**RE: Telopea Concept Plan and Stage 1A Residential, Retail, Child Care and Aged Care –  
Adderton Road, Telopea – SSD-14378717  
Transport and Accessibility Impact Assessment Addendum**

The objective of this TAIA Addendum is to provide responses to the traffic and transport related RFIs received from City of Parramatta Council (Council), NSW Department of Planning, Industry and Environment (DPIE), and Transport for NSW (TfNSW).

1:250 NAT

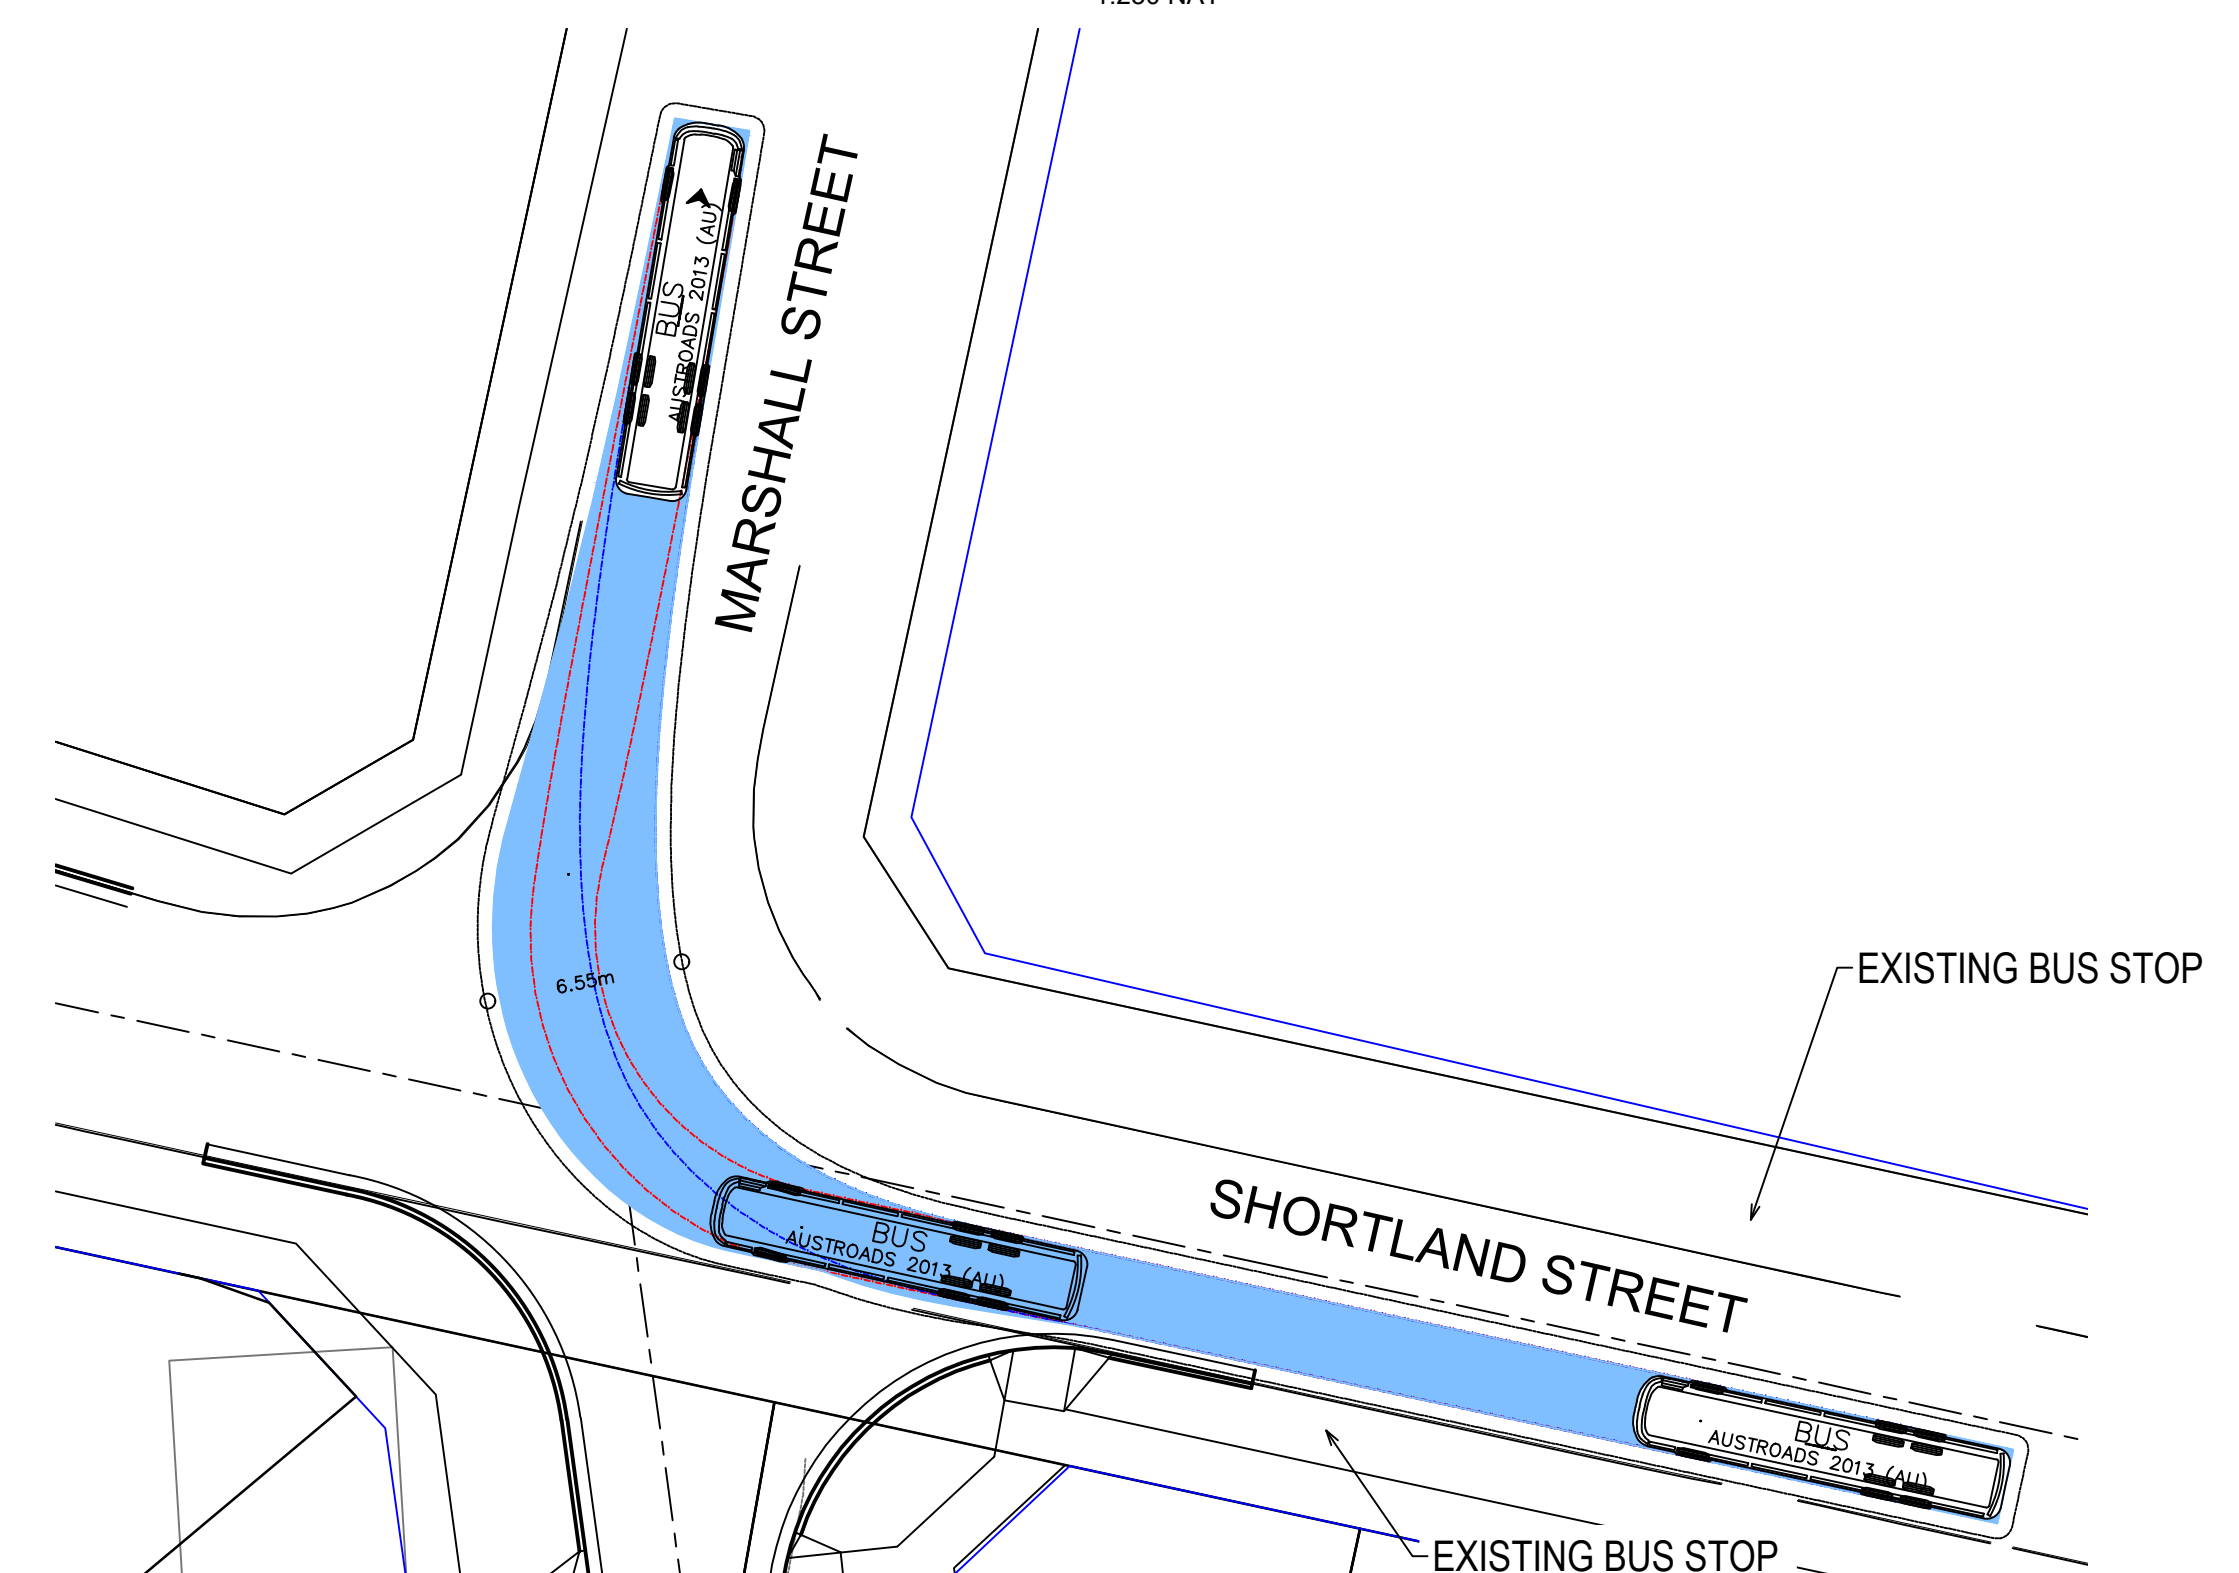
<p><b>14</b></p>	<p><b>Waste Management</b></p>	
<p><b>14.2 Comments (Attachment B) - Waste Truck</b></p>	<p>Trucks are required to enter and exit in a forward direction and the use of a turn table is not permitted. Council requires trucks to be able to enter and exit in a forward within a threepoint turn. From the provided plans, it is not clear whether the waste holding area is located sub-street level. Further detail is required to understand the access, as access into areas below street level is generally not supported. Council also requires 4.5M clearance height throughout the truck's entire travel path. All paths travelled by a waste truck will need to be rated to support a 25t vehicle.</p>	<p>The use of a turntable for service vehicle trucks is acceptable as it is permitted under relevant Australian Standards and is used at a number of developments within Greater Sydney, including elsewhere in the City of Parramatta.</p> <p>Conversely, to design for a 12.5m HRV truck to enter in a forward direction, manoeuvre on-site for loading and then exit in a forward direction would result in a significant impact on the development and would represent a poor design outcome for a vehicle that only occasionally requires access to the Site.</p>
